March 8, 2018

Subject: Final Development Plan for the Hyak Amended PUD (File Z-87-00002 & Z-93-00003) – Transmittal of Comments

RE: Hyak PUD Addendum

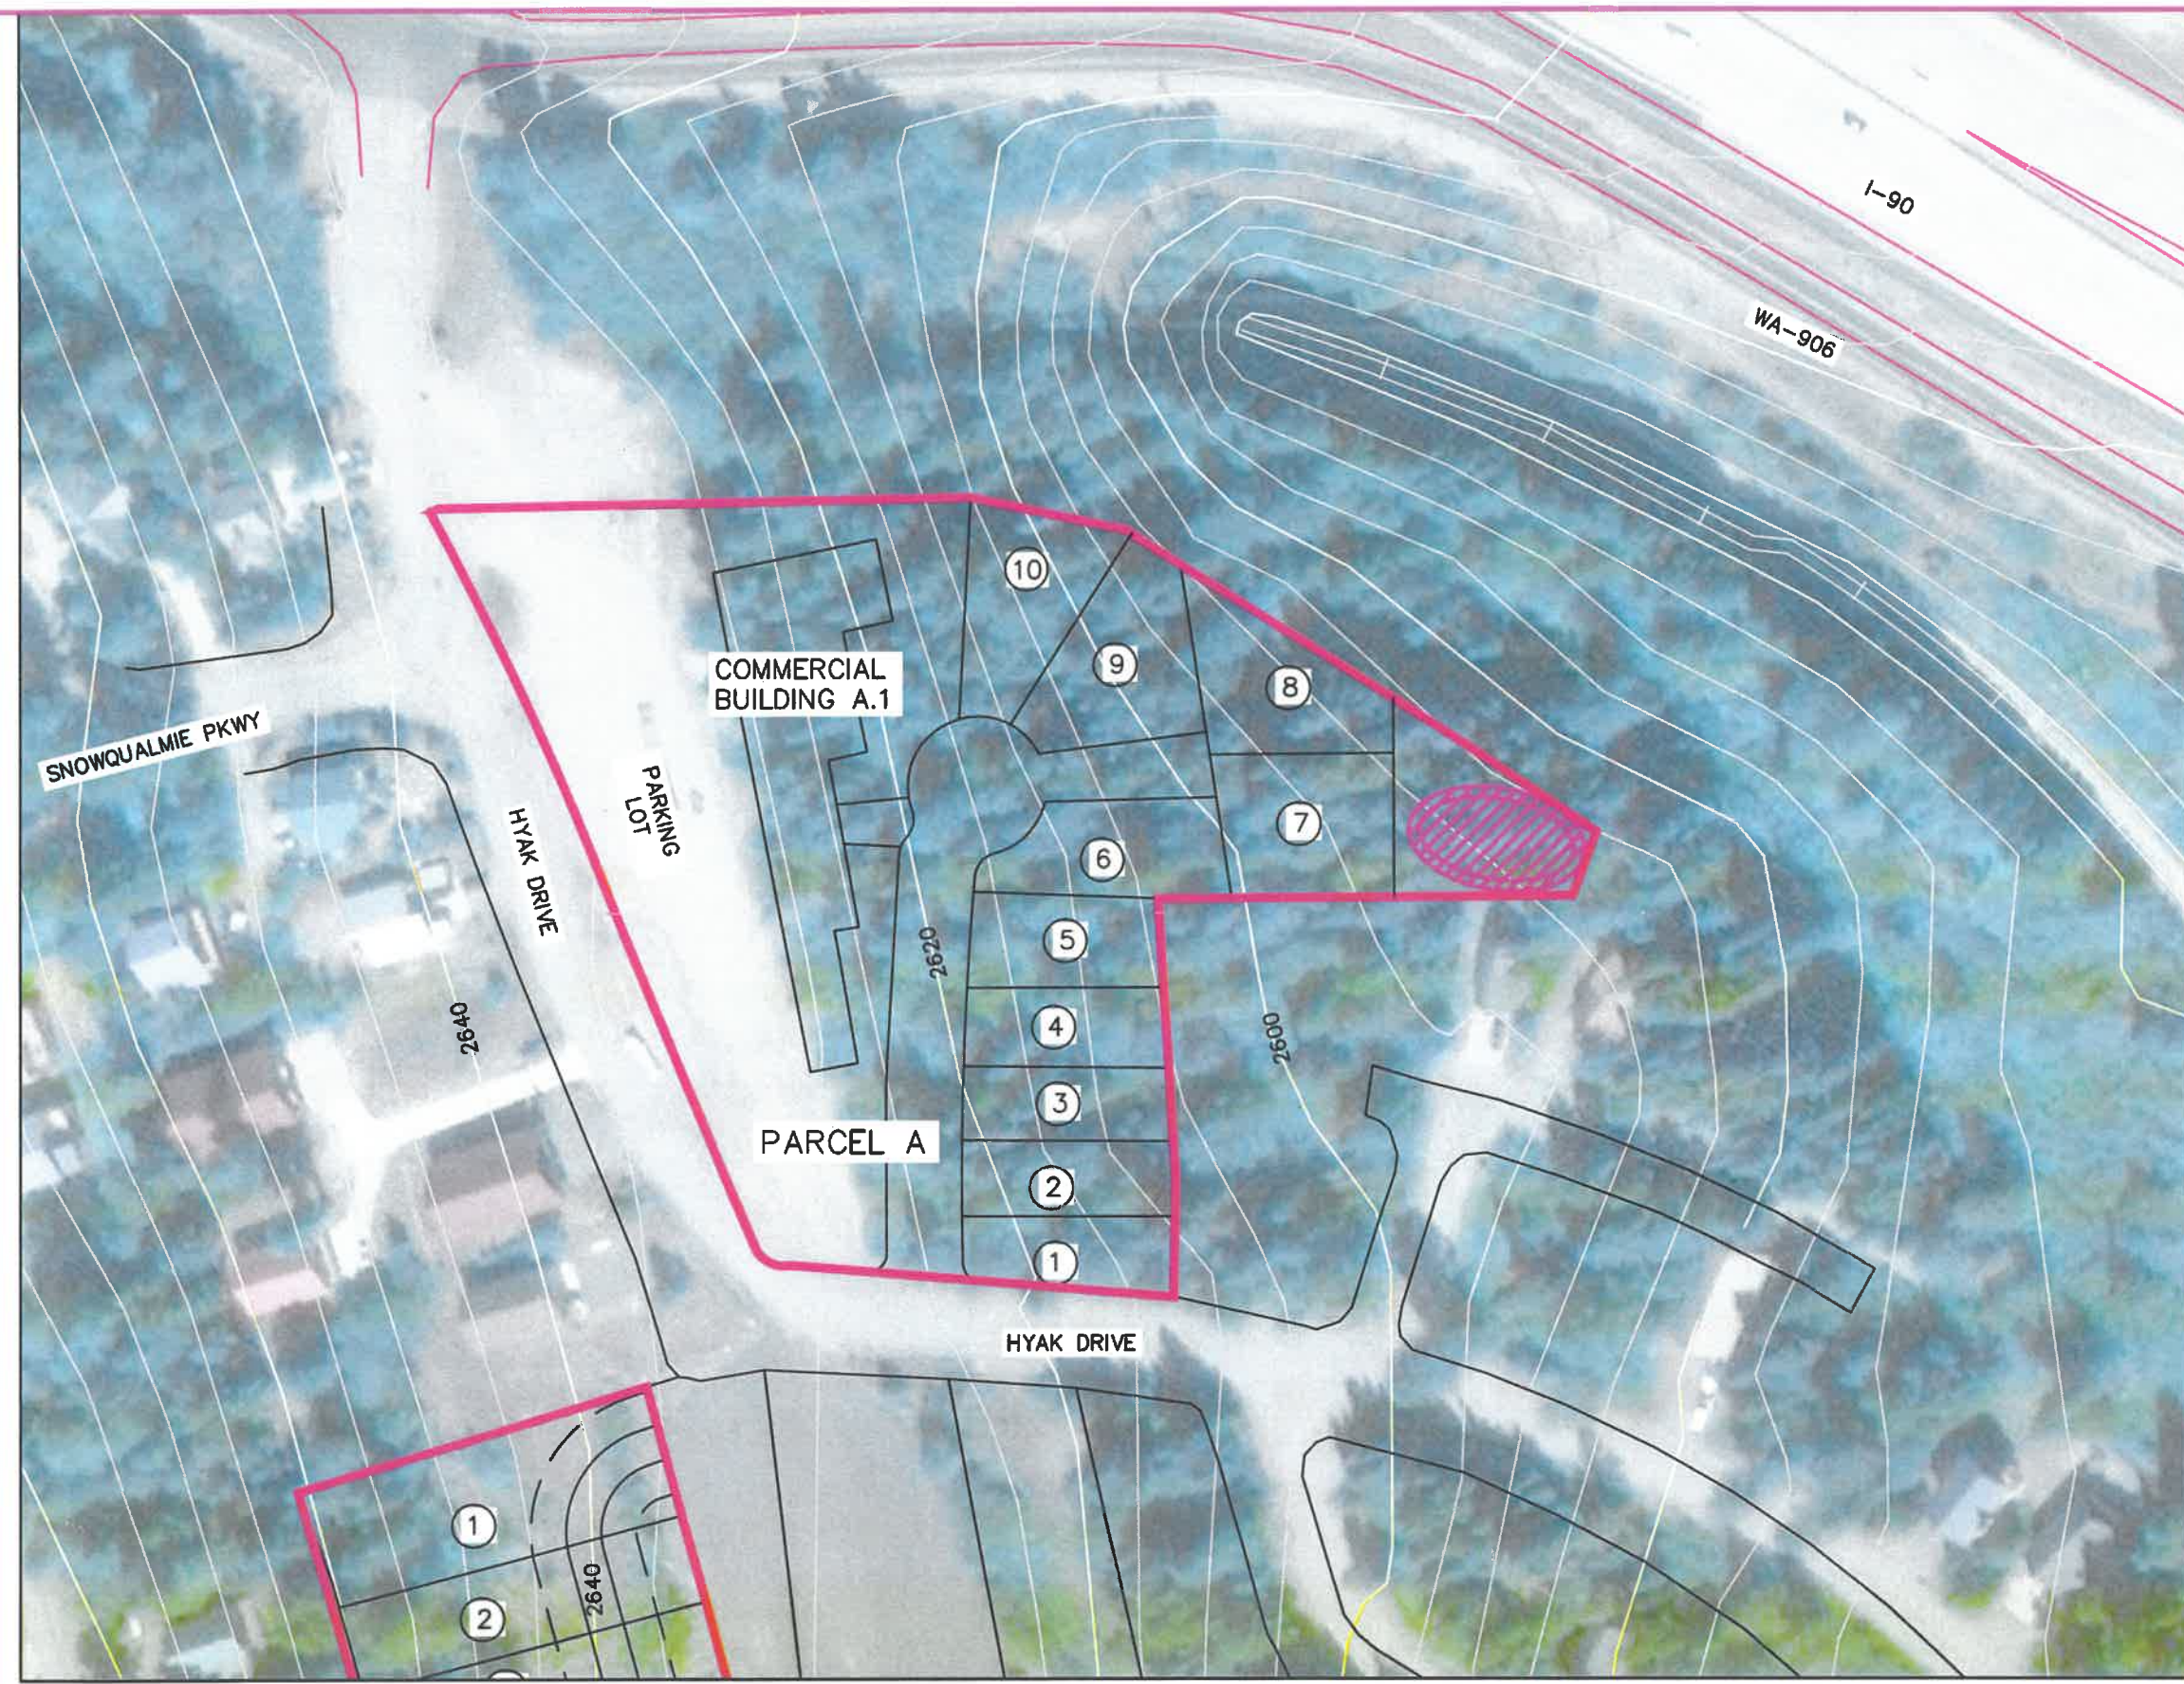
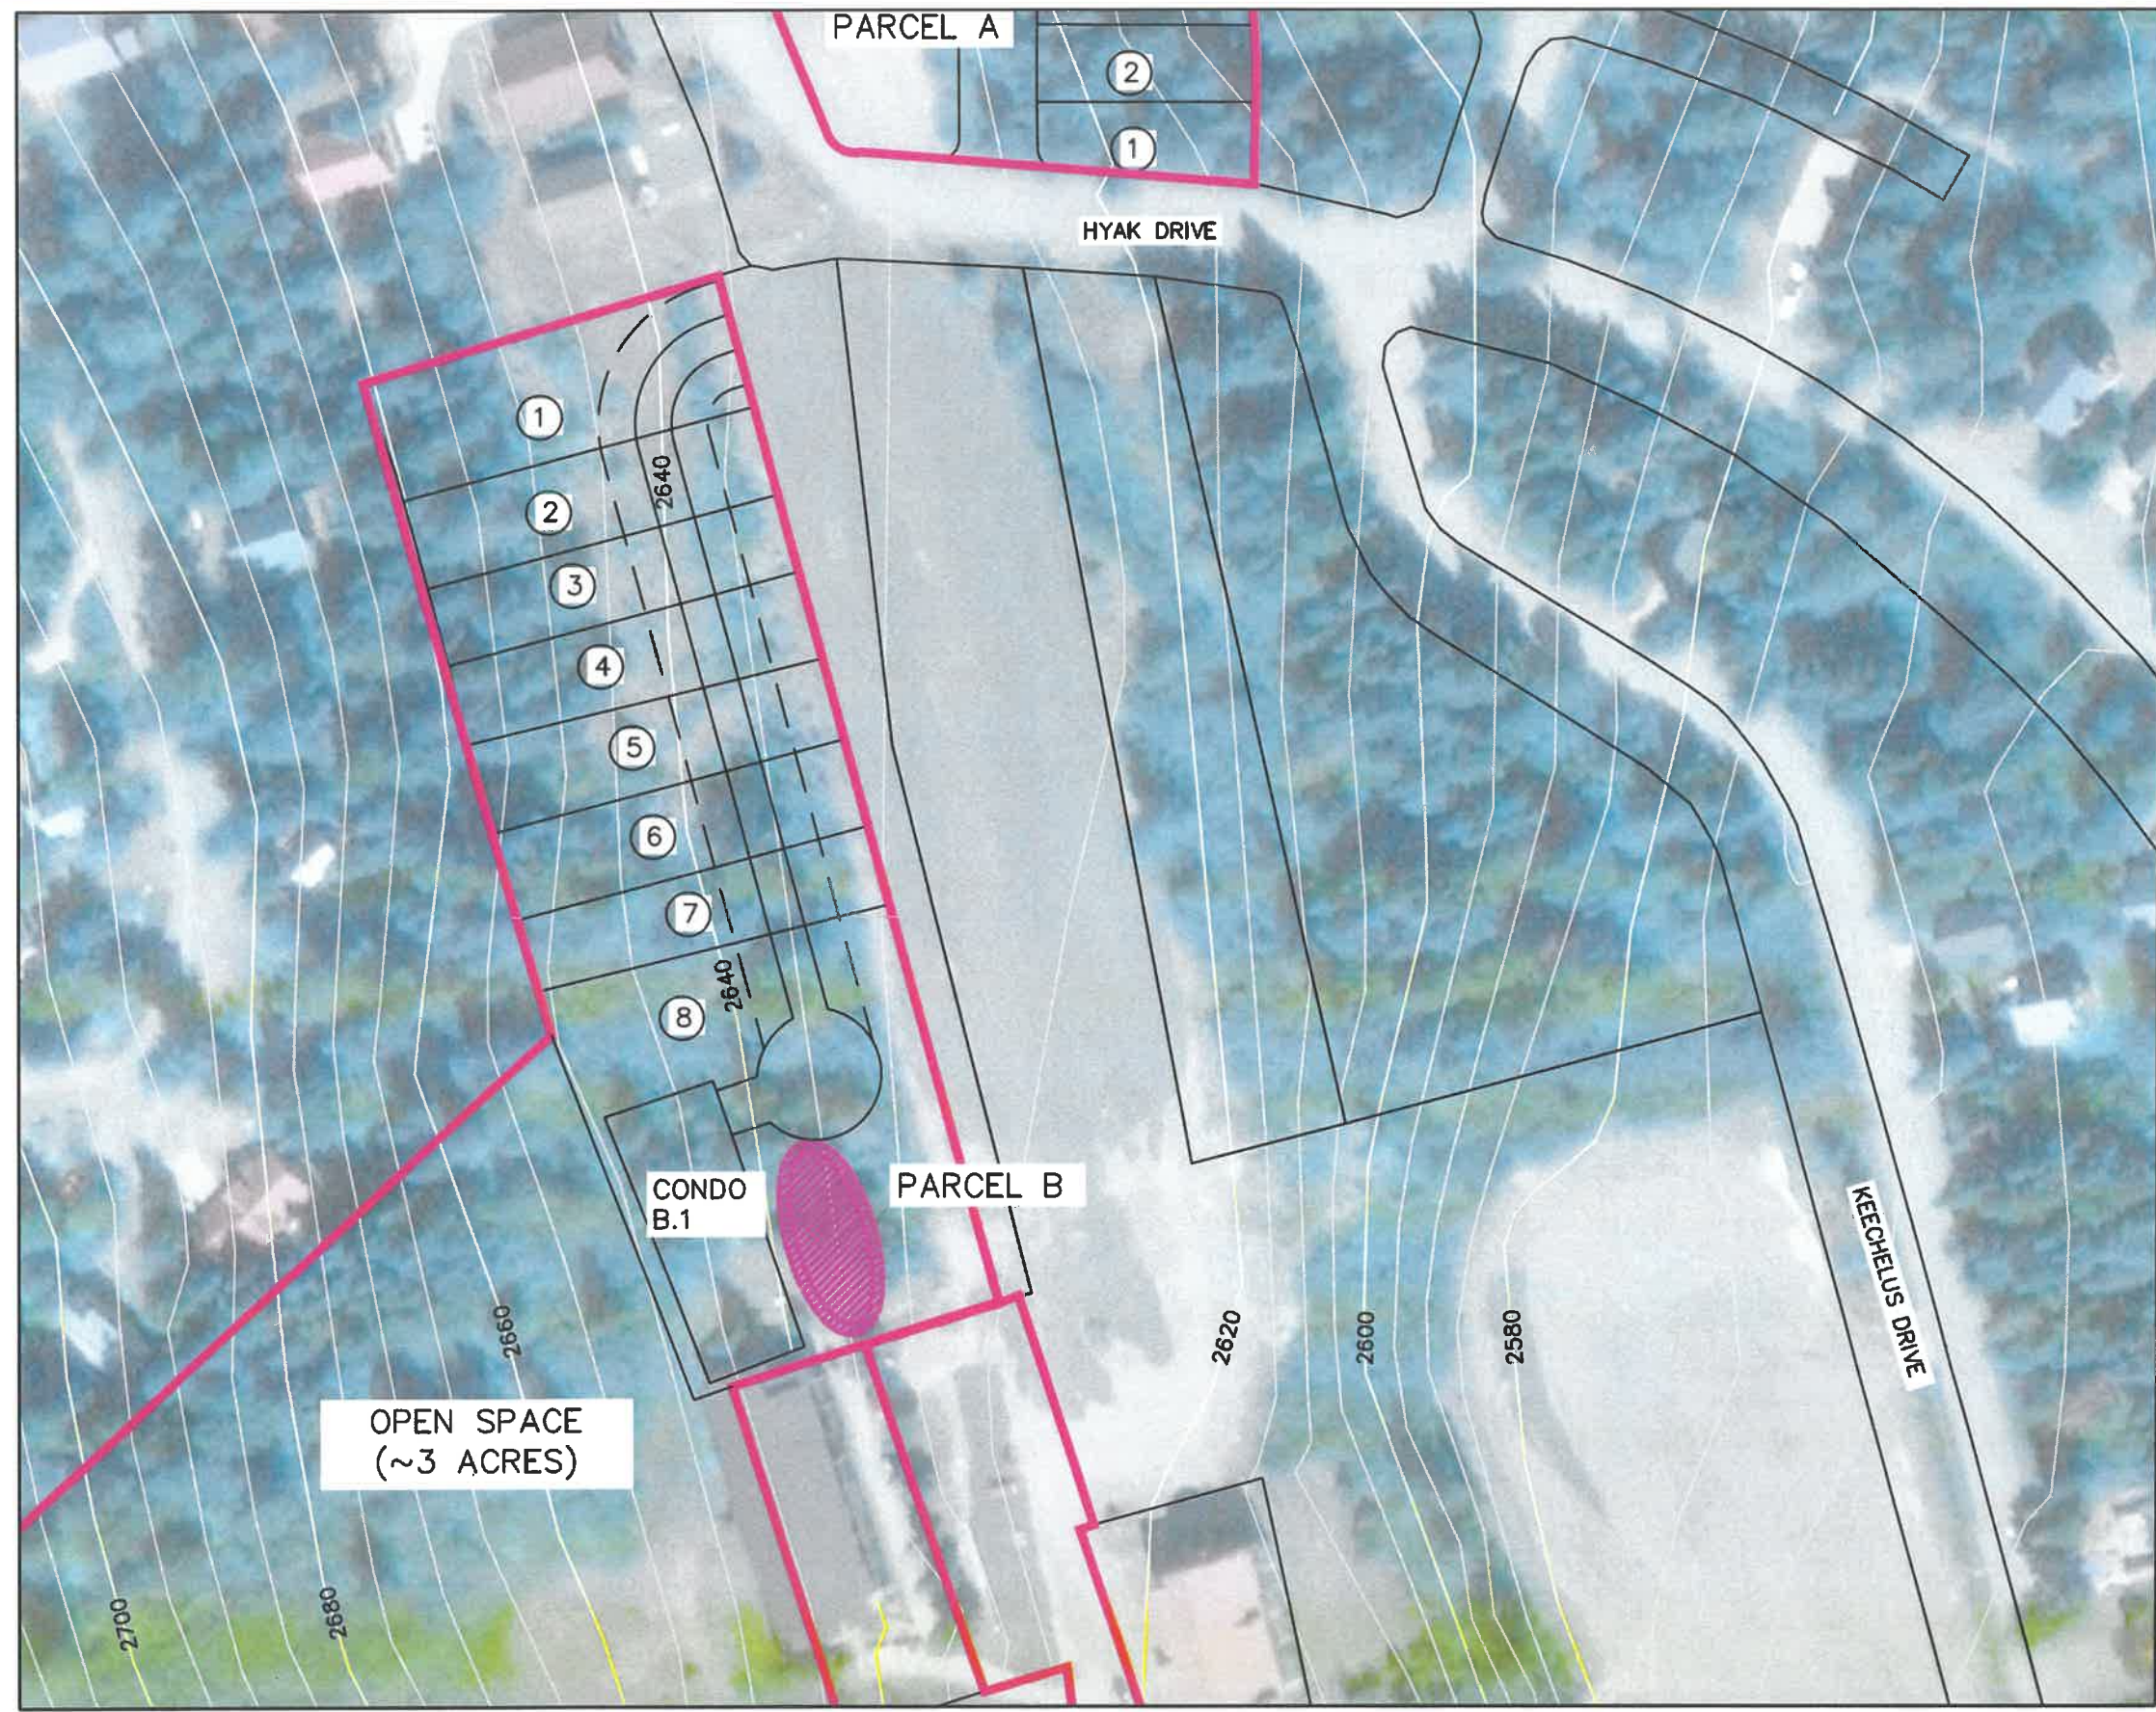
1. Several of the proposed stormwater ponds appear to span multiple contour intervals. The contour interval appears to be five feet. Please be advised that constructing the proposed ponds will likely impact developable land in the vicinity of the ponds. Public Works will assess the viability of pond construction on hill side slope at the time of civil engineering design submittal.
